**From:** Sue Howell  
**Sent:** 26 January 2015 15:56  
**To:** Planning.Responses  
**Cc:** Simon Davis  
**Subject:** RE: Planning Consultation on BE/152/14/DOC

Comment from Greenspace

**APPLICATION**                      **BE/152/14/DOC**  
**NO:**

**Registered:**                      18-DEC-14  
**Site Address:**                    Blue Haze Shripney Road Bersted PO22 9NU  
**Description of**                    Application to discharge condition 2 from

Scale: 1 : 100 at A1	Drawing no 248-01-01	Drawn: Checked DH DH
--------------------------------	--------------------------------	--------------------------------

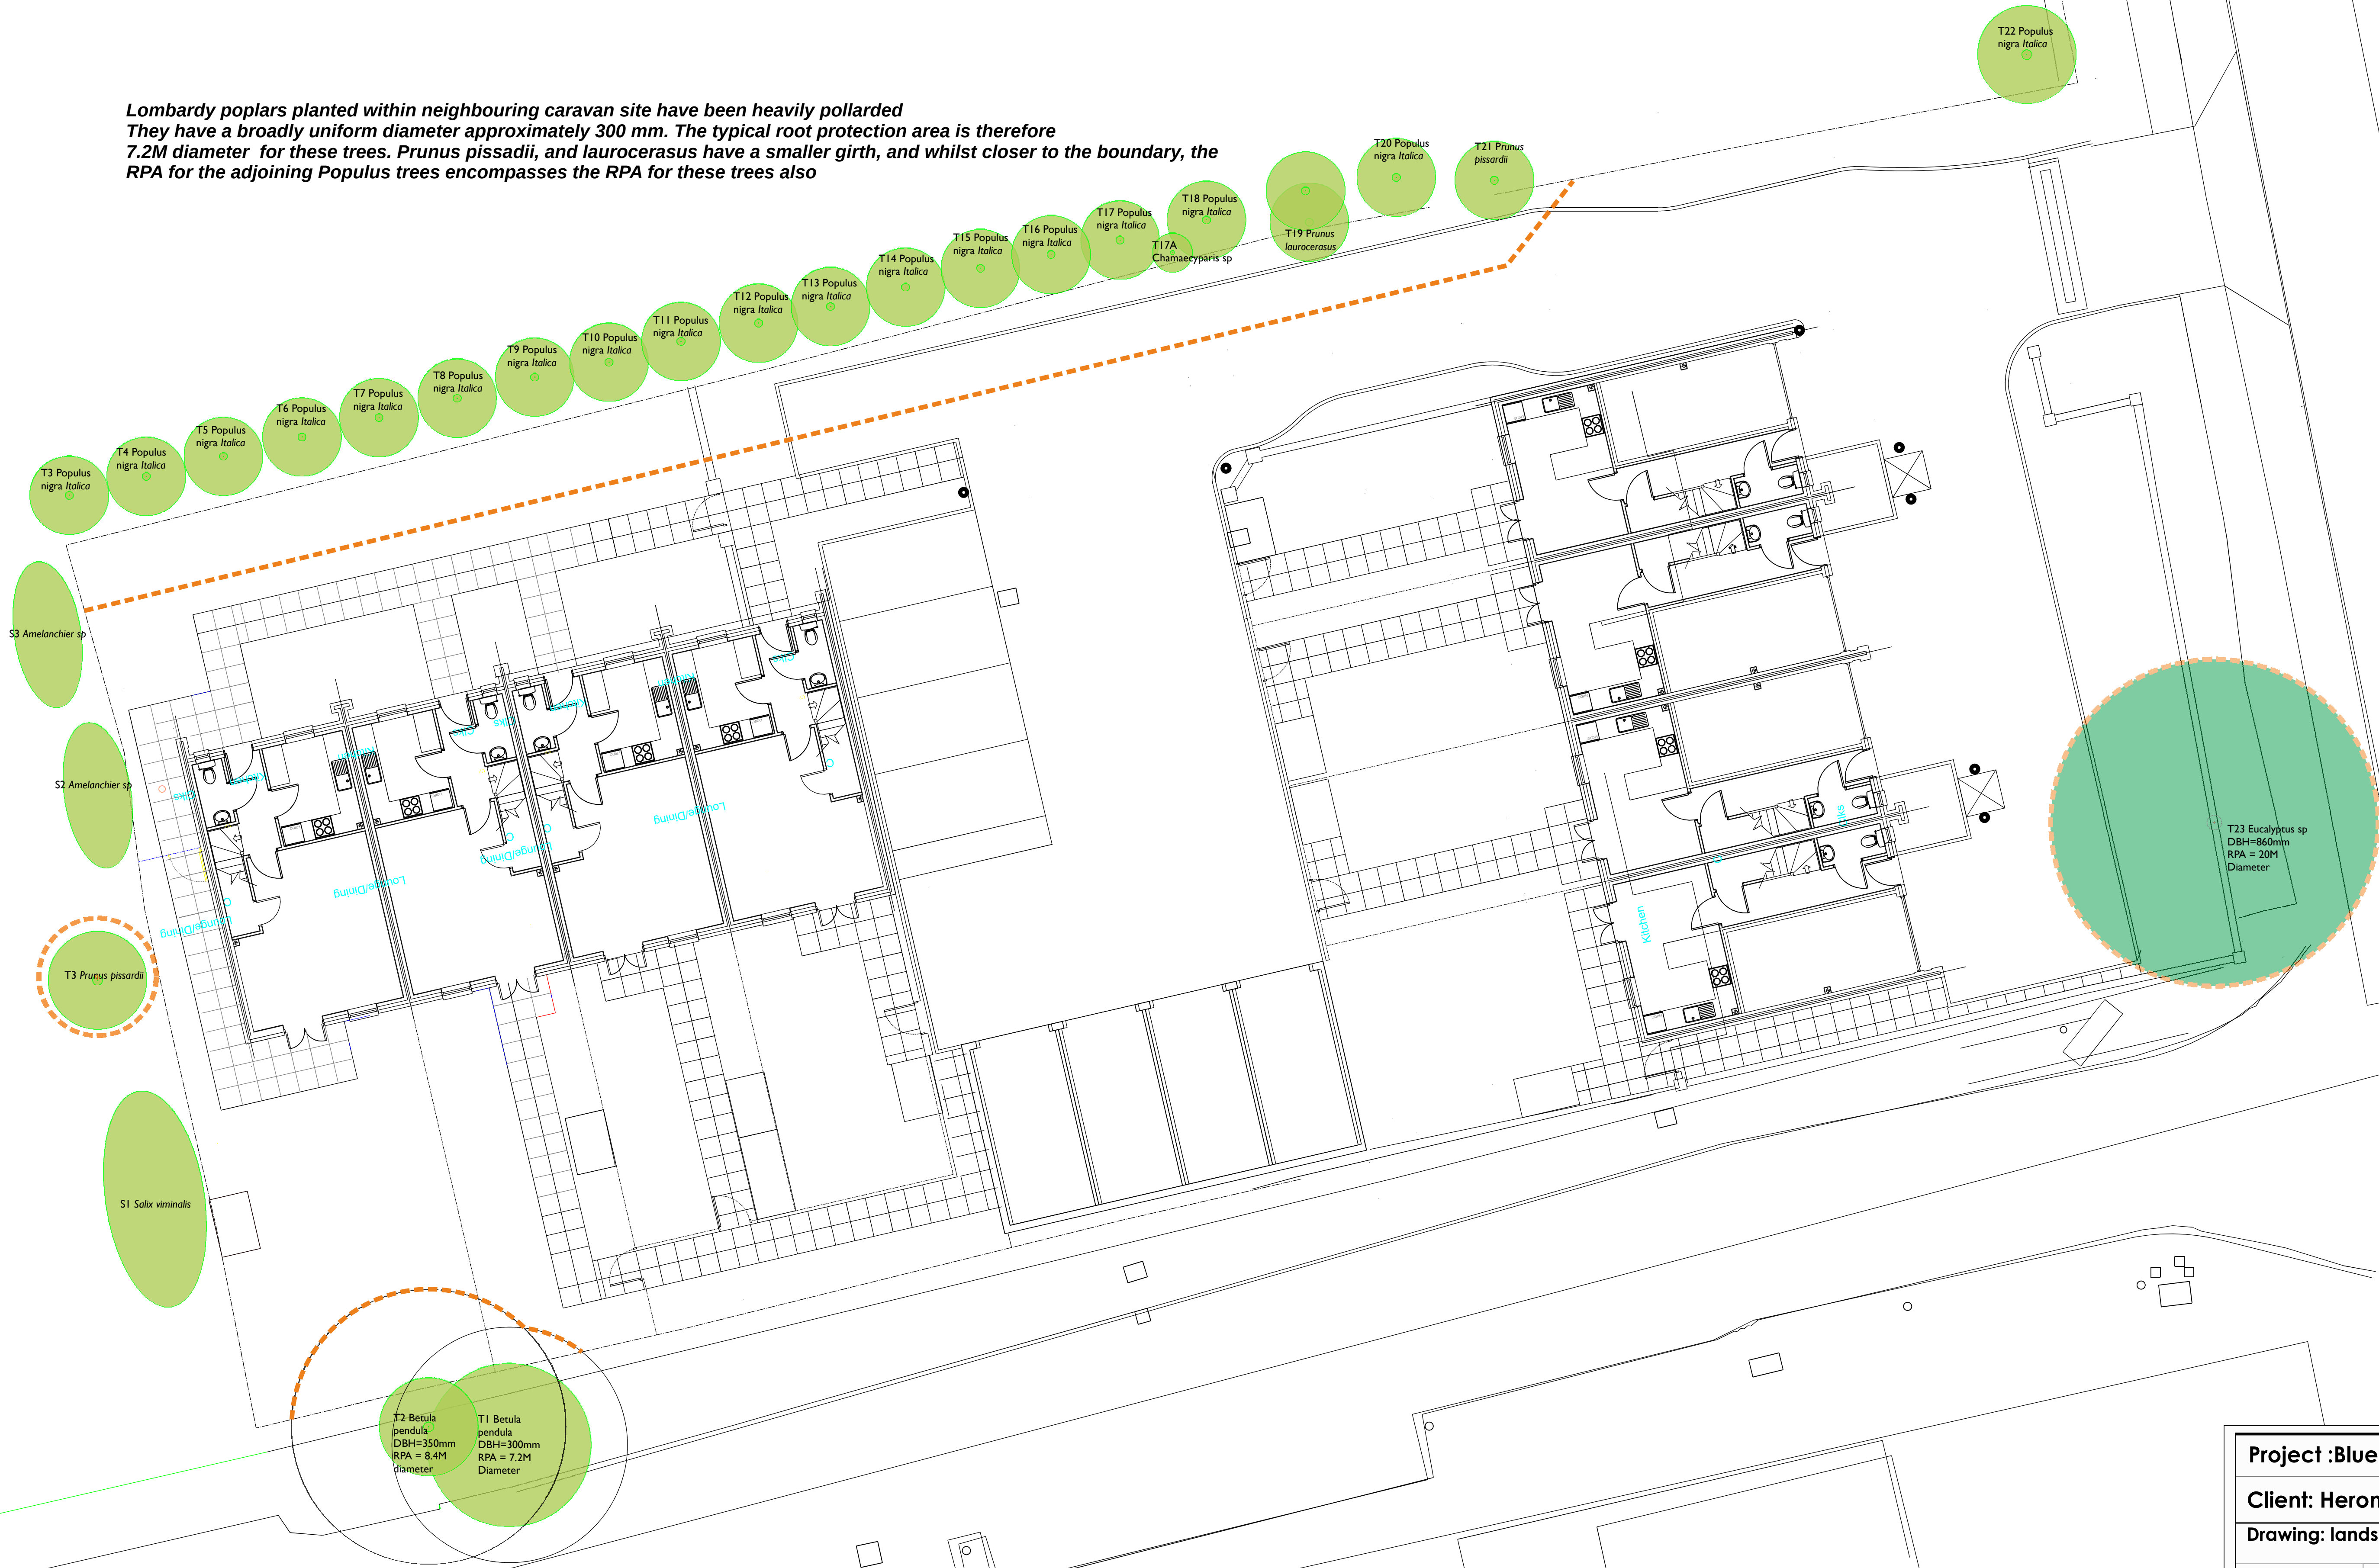
Further to submission of Dwg 248-01-01 Tree protection plan and Dwg 248-01-02 Planting Plan, we confirm that the information has been assessed and is still seen to be lacking in clarity for some of the areas. There is no detail included for beds 13,14,15,16 which partially border the front of the site. There are also specimen shrubs shown on the plan, but again these are not detailed within the legend.

We therefore **would not recommend the discharge of Condition 2** on this application until this information is submitted and approved.
